PLANNING APPLICATION REPORT**REF NO:** M/35/08/**LOCATION:** 26 Sea Way
Elmer Sands
Middleton on Sea**PROPOSAL:** Extension and alterations to provide 3 bedrooms, bathroom, ensuite and stairhall.
(Resubmission following M/154/07)**SITE AND SURROUNDINGS**

PROPOSED
ELEVATIONS

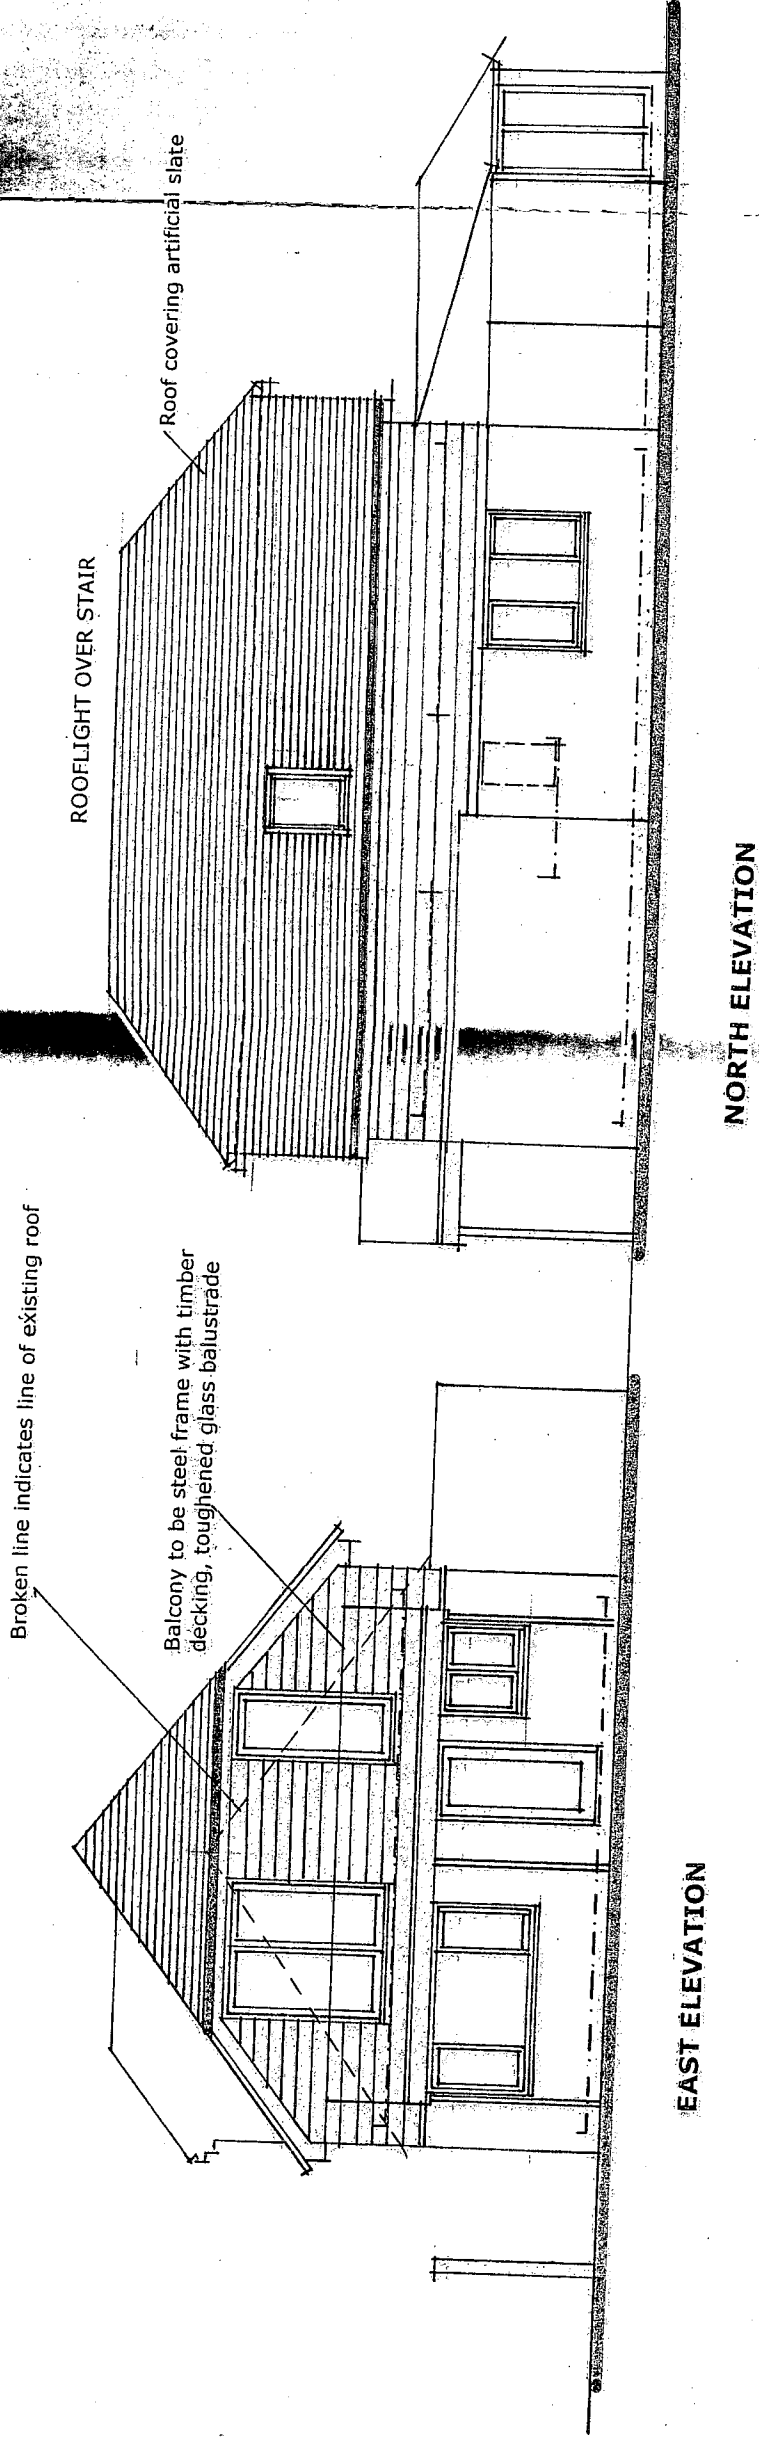
The windows on the western elevation will overlook our property. The proposed extension constitutes over development of the site when compared to the size of the plot and the adjacent properties. No provision has been made for off-street parking that may be required for a house of this type. The neighbouring property No 28 will lose light and sunlight particularly during the winter months).

Noted. The proposal would introduce two new windows at first floor level in the west facing elevation but the distances between properties mean this would not result in significant harm by reason of overlooking. Although the extension is not visually subservient to the main dwelling it is not considered that the proposal would be an overdevelopment of the site, unneighbourly to neighbouring properties or obtrusive in the street scene. For these reasons and those set out in the conclusions section of this report, the proposal is recommended for approval.

There are two windows proposed on the rear which serve the bedroom and bathroom and the bathroom window will have obscure glazing. It is considered that there is adequate distance retained between the proposal and No 1 not to cause harmful overlooking or loss of privacy to the occupiers of this property. The neighbouring property to the south No 24 is set back from the proposal and it is not considered that the dormer on the south side elevation of the proposal which serves the en-suite would cause any overlooking or loss of privacy to the occupiers of this property. A condition is to be recommended requiring that the window have obscure glazing. The neighbouring bungalow to the north No 28 which is set back from No 26 is approximately 1.5m from the application site. This property has an ancillary lounge window on the south side elevation that will overlook the proposal but due to the position of the roof light on the north elevation which serves the stairwell it is not considered that this would create any overlooking or loss of privacy to the occupiers of No 28. However, the extension may cause some overshadowing and loss of light to the occupiers of No 28 but it is not considered to be of a harmful nature to warrant a refusal. The windows and balcony area to the front of the property may create a certain amount of oblique overlooking and loss of privacy to the properties to the east of the site. However, with a distance of approximately 27m to these properties it is not considered that this would be of an unacceptable level to warrant a refusal.

- 2 The dormer window on the south elevation of the roof extension shall at all times be glazed with obscured glass and shall consist of at least two lights divided horizontally with the bottom light being permanently fixed and only the top light capable of being opened.
